## Comments on the Applicant's D5 submissions

This document sets out the comments on the Applicant's Deadline 5 (D5) submissions by Cambridgeshire County Council (**CCC**), Huntingdonshire District Council (**HDC**) and South Cambridgeshire District Council (**SCDC**) (together, the **Councils**). The tables below set out the document in question that the Councils are commenting on, together with the relevant paragraph or reference number.

### 9.54 Barbastelle Bat Surveys and Mitigation Technical Note (Rev 2) [REP5-006]

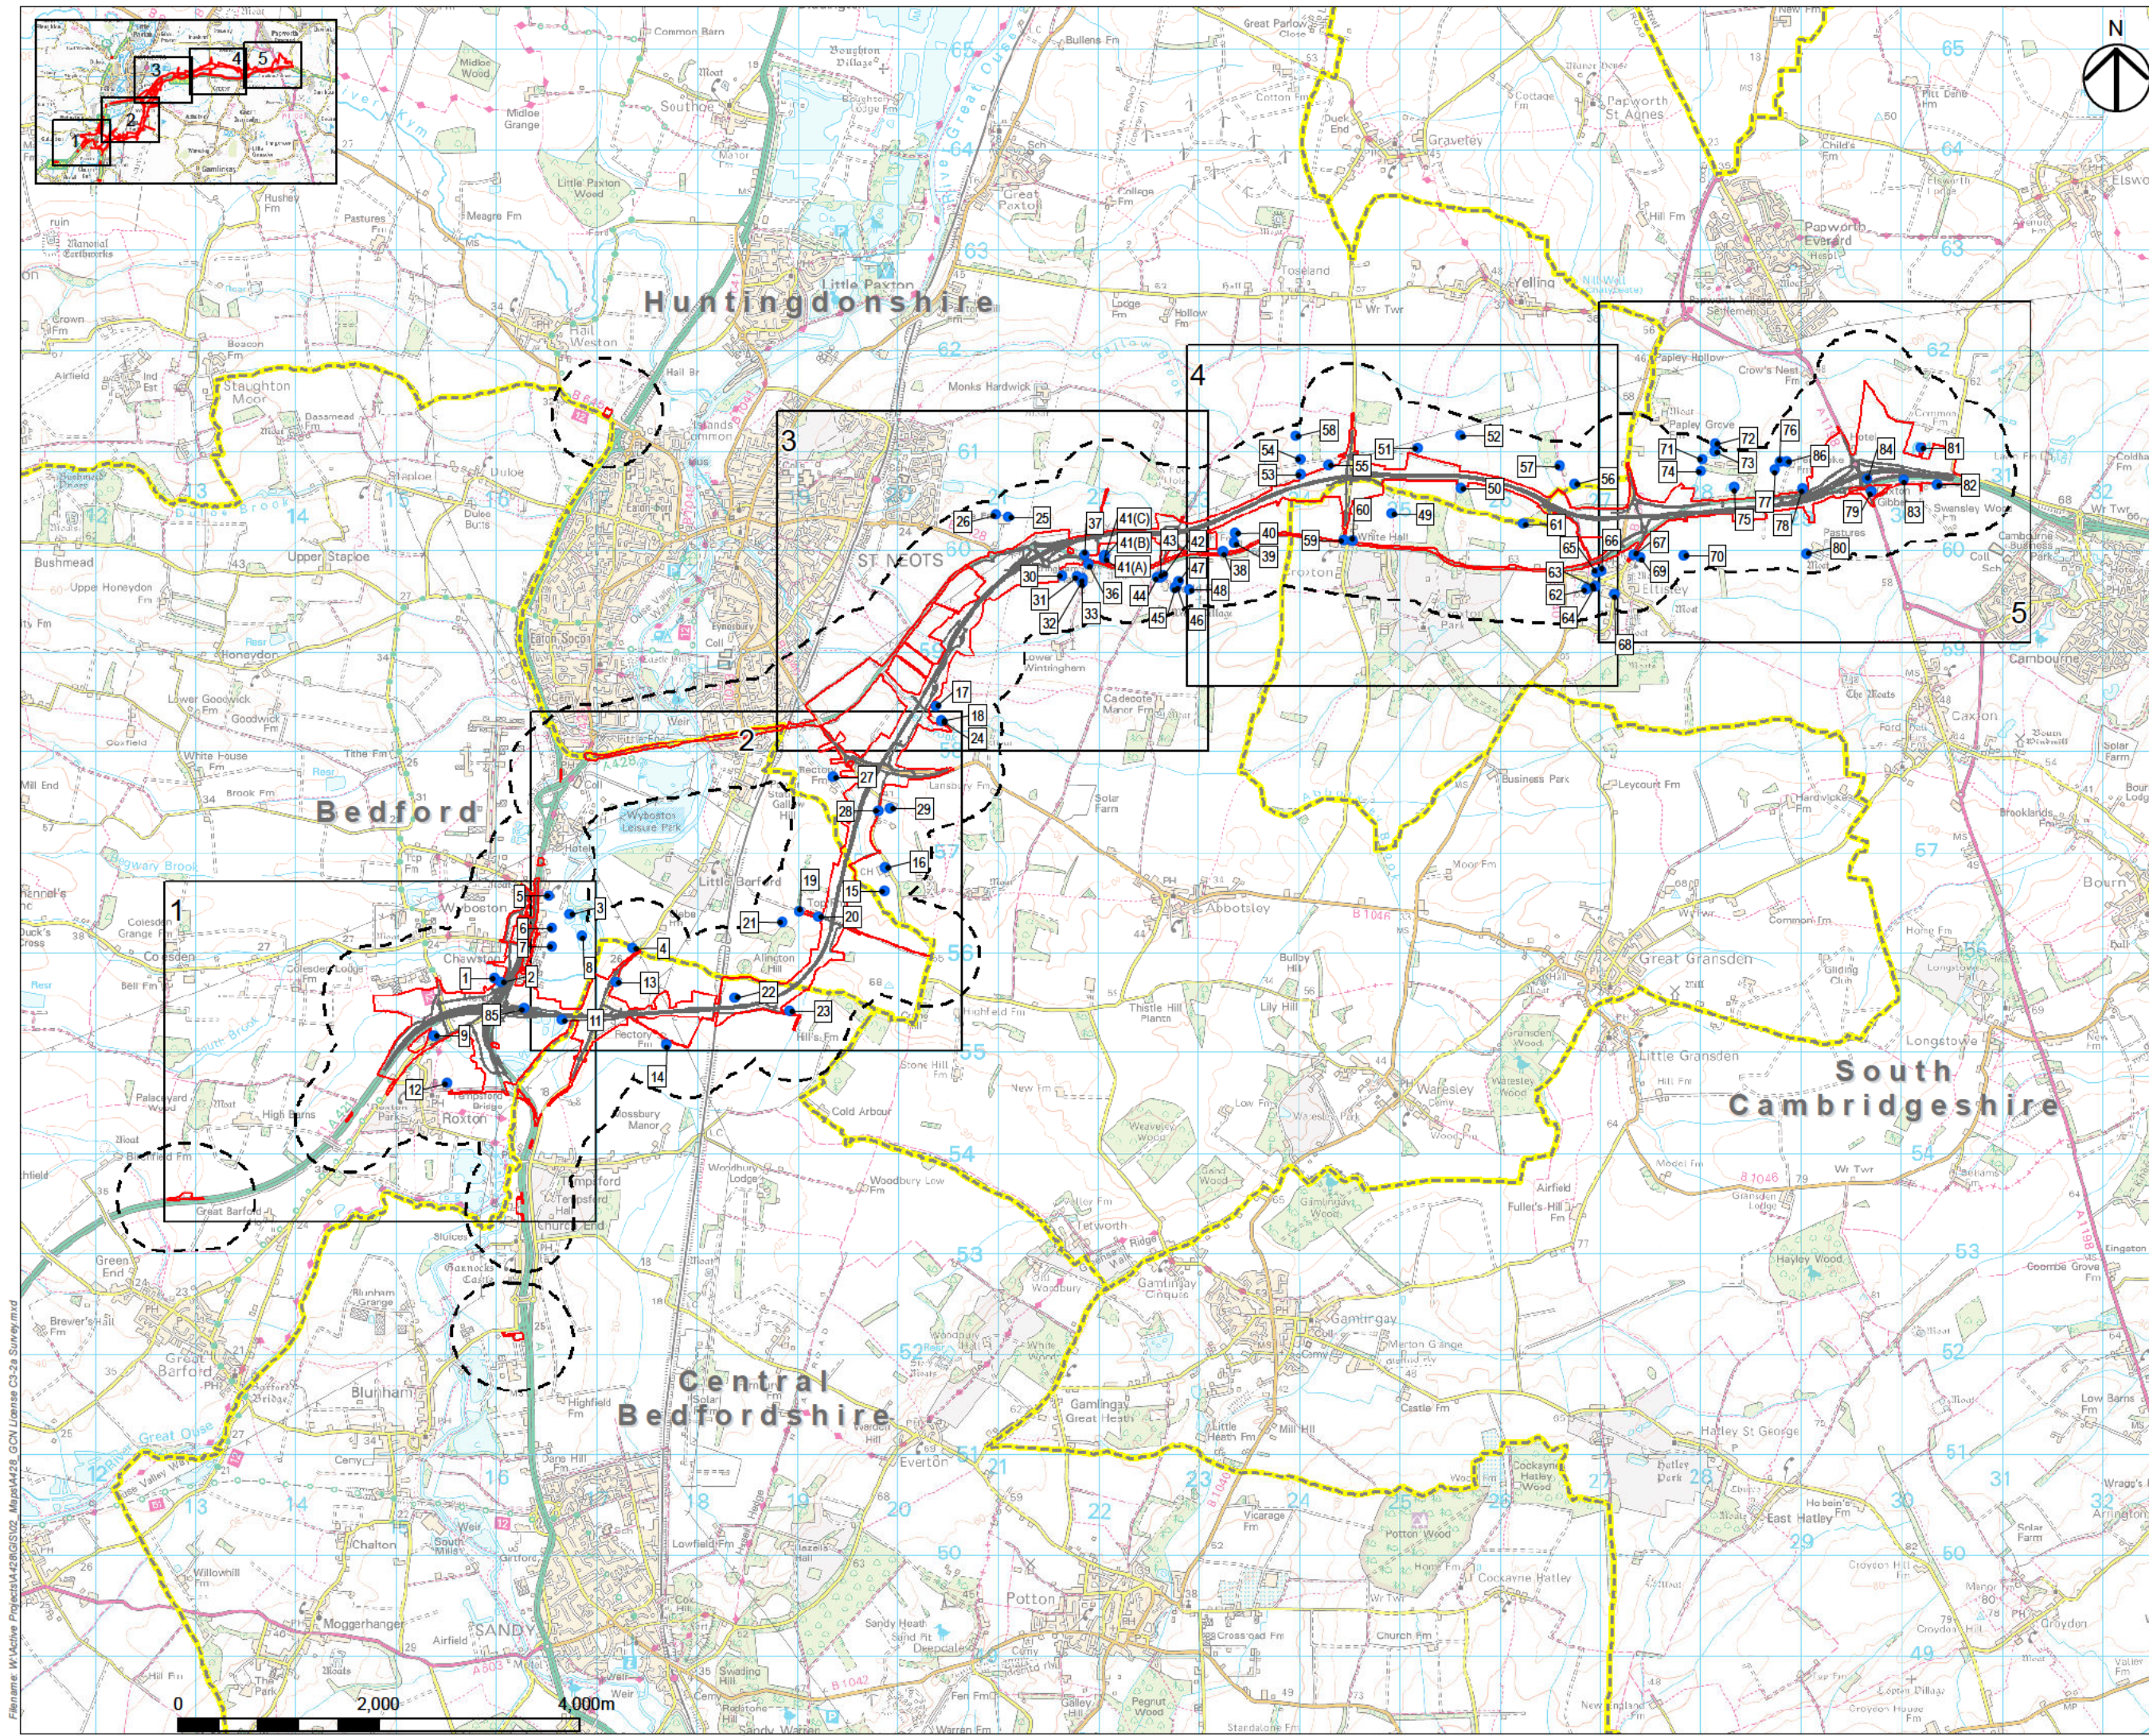
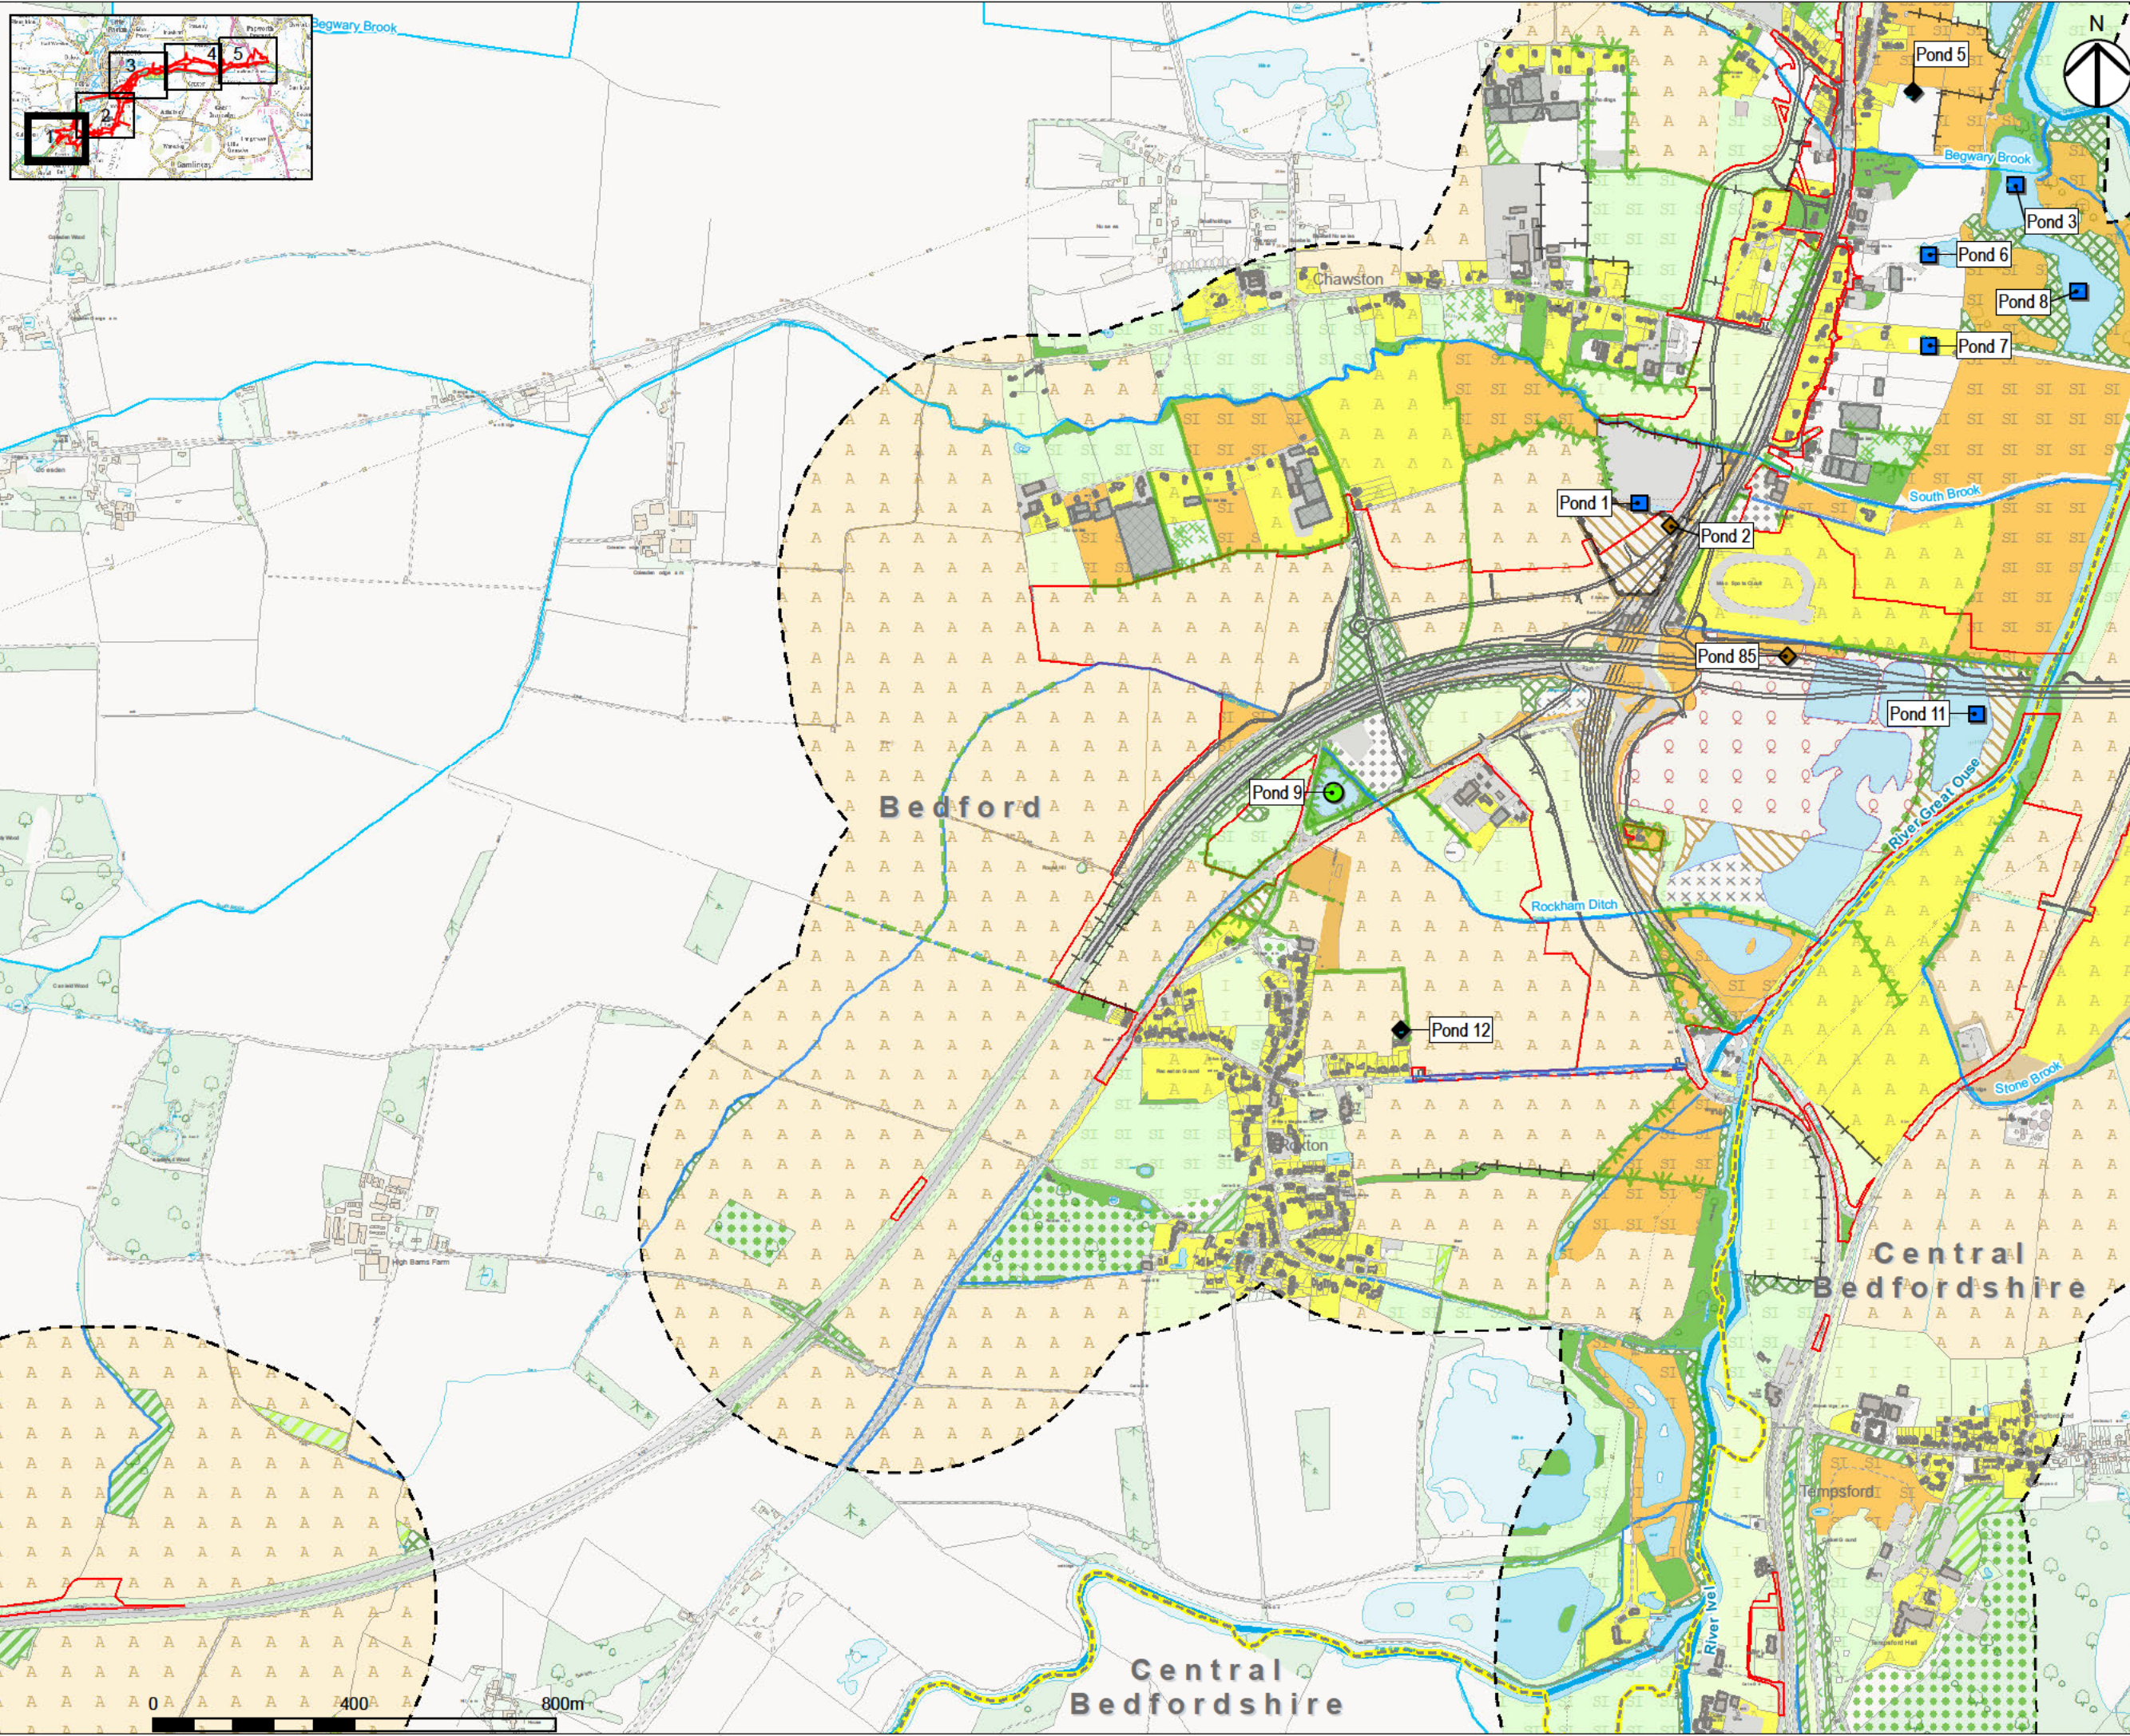
Pond 84	7.3.1	<p>Pond 84 is one of two ponds that will be lost in Cambridgeshire as a result of the proposed development.</p> <p>Pond 84 was found to be dry in 2021. We support National Highways conclusion that the pond is unlikely to support any regular breeding by Great Crested Newts. Therefore, this addresses our previous concern with regards to the loss of this ponds for GCNs.</p>
---------	-------	---
